Our Ref: ID 1723
Your Ref: SSD-38600121

04 October 2022

Environmental Impact Assessment for the State Significant Development (SSD) Alexandria Health Centre 28-32 Bourke Road Alexandria

Figure 7 1% AEP Flood Map

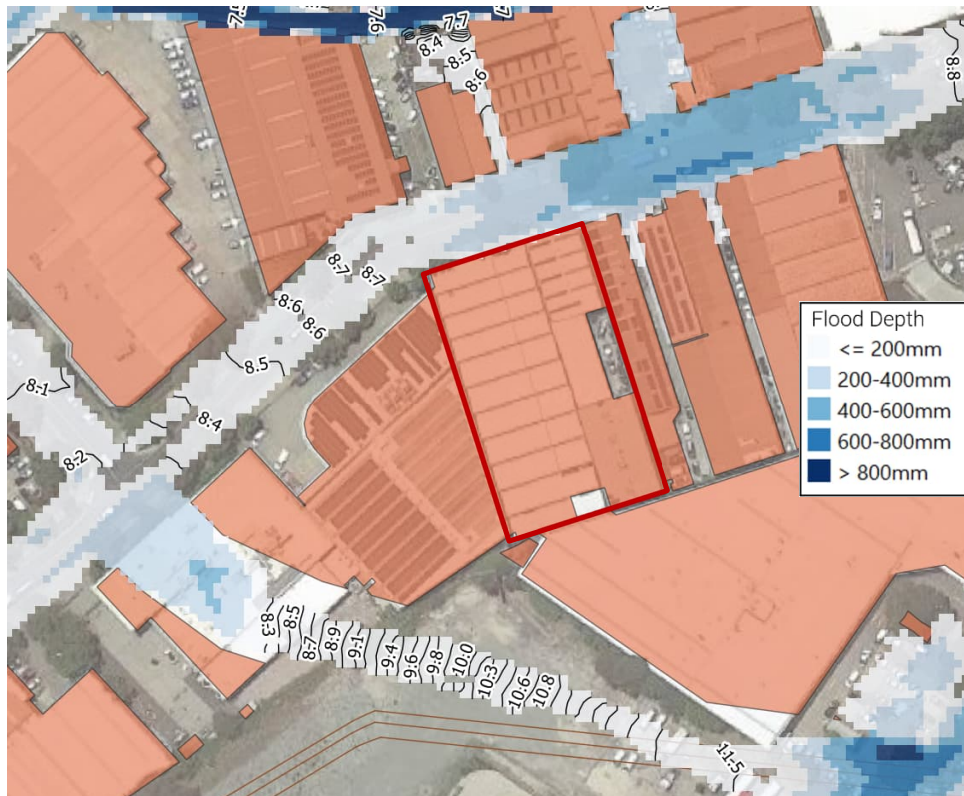
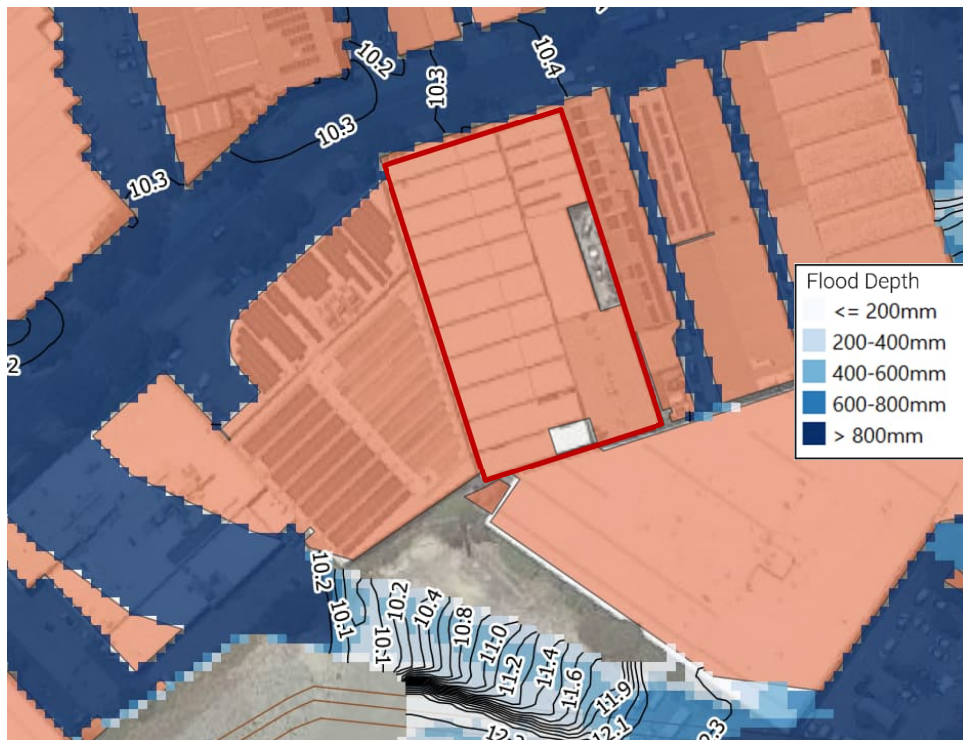
- **Development should not result in an increase in risk to life, health or property of people living on the floodplain.** It appears the site is isolated by flooding around the 10% AEP event (Alexandra Canal Catchment Flood Study, 2010). This is considered quite frequent in occurrence. The Civil Engineering Draft SSDA Report from July 2022 (the Report) identifies that the site is *“located near a sag point on Bourke Road and is located in a high flood risk zone with major overland flow expected at or near the site”*. The proposal of a new hospital on highly flood prone land should receive the highest level of scrutiny due to the critical and sensitive nature of the proposed use as identified in the EHG response (dated 15/08/2022).

- **Risk assessment should consider the full range of flooding, including events up to the Probable Maximum Flood (PMF) and not focus only on the 1% AEP flood.** Although this has been addressed in the Report, consideration of emergency access and egress has not. Further detail regarding the duration and frequency of inundation is also required. Long duration events must be considered as these will dictate the maximum duration of isolation. The site is affected by mainstream flooding, so longer durations may occur as detailed in the EHG response (dated 15/08/2022).

- **In the context of future development, self-evacuation of the community should be achievable in a manner which is consistent with the NSW SES’s principles for evacuation.** Clarification is required for the basement level proposed, and how it will be designed to be protected from floods up to a PMF. Research has demonstrated that basement levels, including basement car parking can be particularly vulnerable to flood risks, as floodwaters can enter a basement at a rapid rate once the entry threshold level is exceeded (e.g. [Collier et al, 2017](#)).
